## Department of Primary Industries

FE20/527  
05 June 2020

**RE: *Bowdens Silver (SSD-5765) (Mid-Western Regional)***

DPI Fisheries have reviewed the EIS and offer the following comments. Generally, DPI Fisheries concur with the conclusions of the aquatic ecology assessment however, have a number of comments and recommendations as below;

Figure 1 – Mine Site layout (source: R.W. Corkery & Co. Pty Limited, 2020).

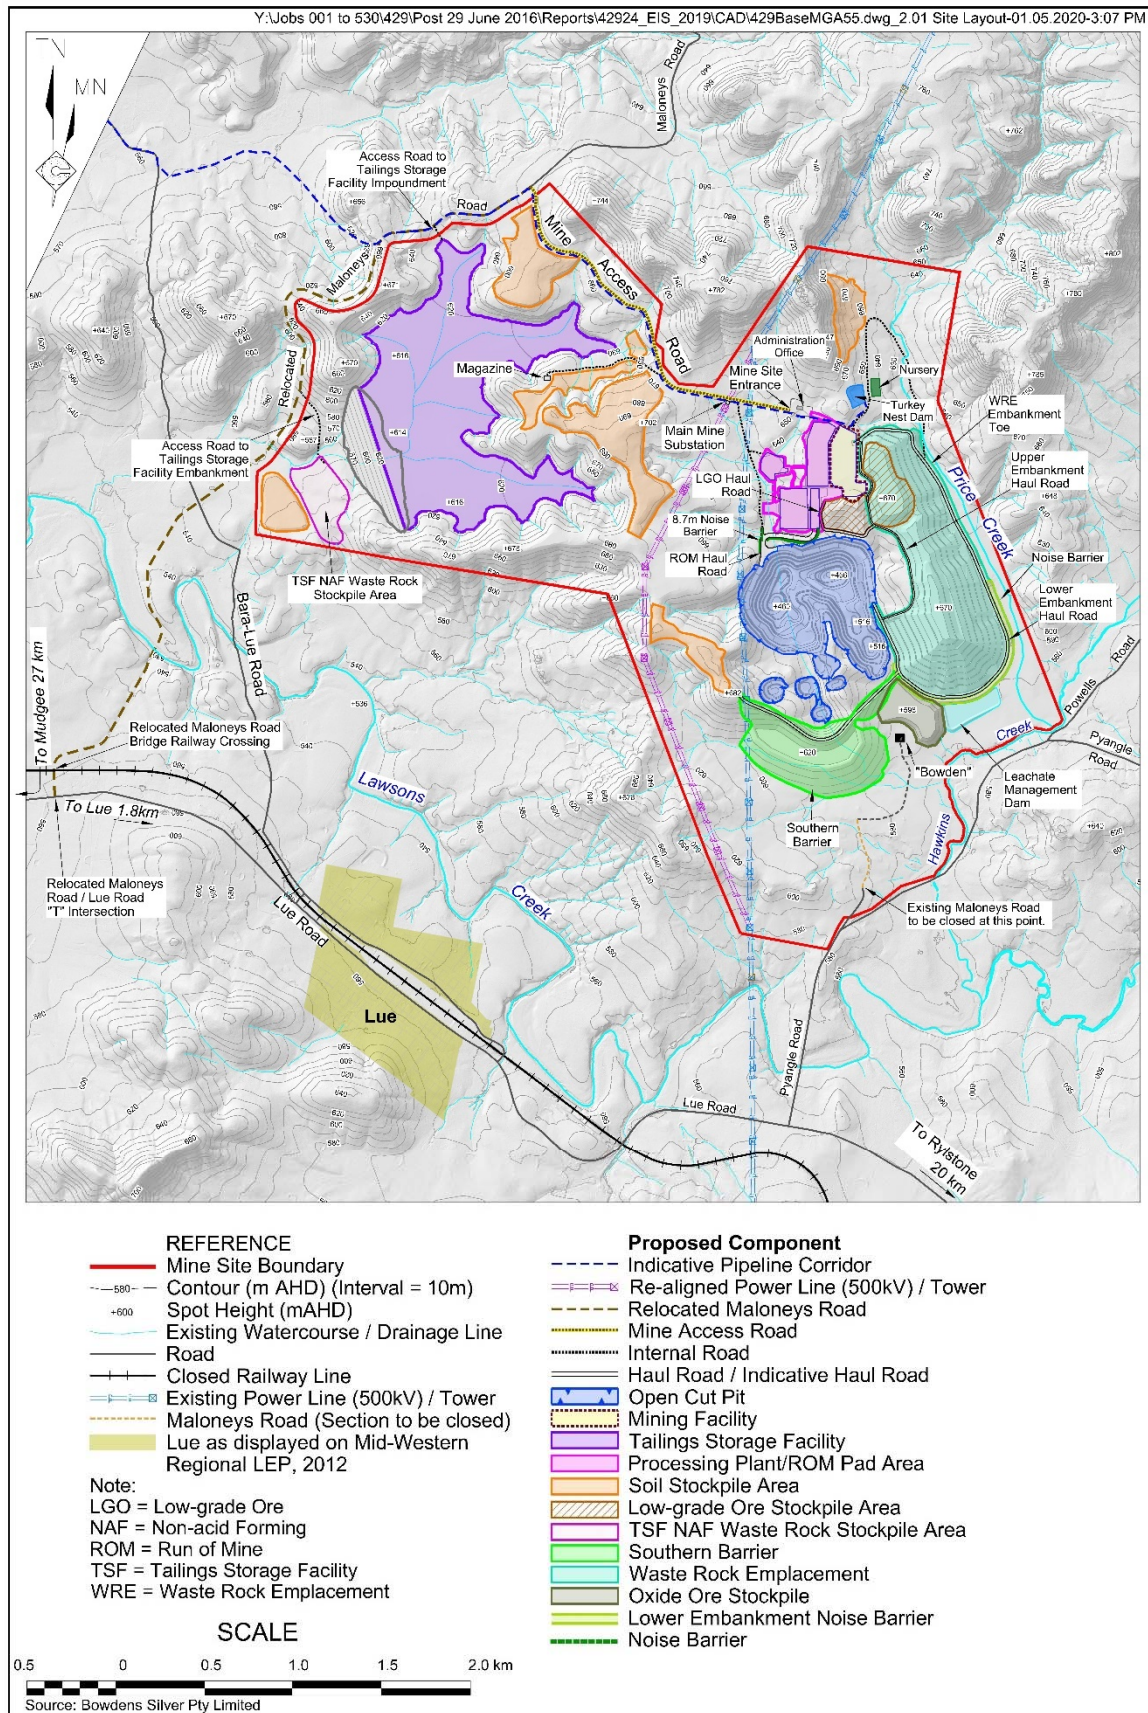
Whilst the riparian buffer zones to most of the waterways appear to adhere to the recommendations within the *Policy and Guidelines for Fish Habitat Conservation and Management (Update 2013)*, the minimum riparian buffer zone of 50 metres for a TYPE 2 CLASS 3 waterway such as Price Creek evidently has not been established from maps of the proposed mine site layout, whereby the toe of the waste rock emplacement encroaches well into the buffer zone. This incursion into the riparian buffer zone is exacerbated further higher up the Price Creek valley.

It is recommended that the proposed toe of the waste rock emplacement on the mine layout site is shifted away from the Price Creek riparian buffer zone in order to maintain a 50 metre buffer zone.

An internal haul road is indicated to cross Price Creek twice north of the Waste Rock Emplacement, however there is no mention of this waterway crossing in the EIS.

Price Creek is a 4<sup>th</sup> order Strahler stream and is classified as a TYPE 2 CLASS 3 waterway in the EIS. Ideally the internal haul road should be redesigned to avoid crossing the creek twice. Alternatively, a waterway design needs to be undertaken in accordance with the Department's Policy and Guidelines *Why Do Fish Need to Cross the Road? Fish passage Requirements for Waterway Crossings (2003)*.
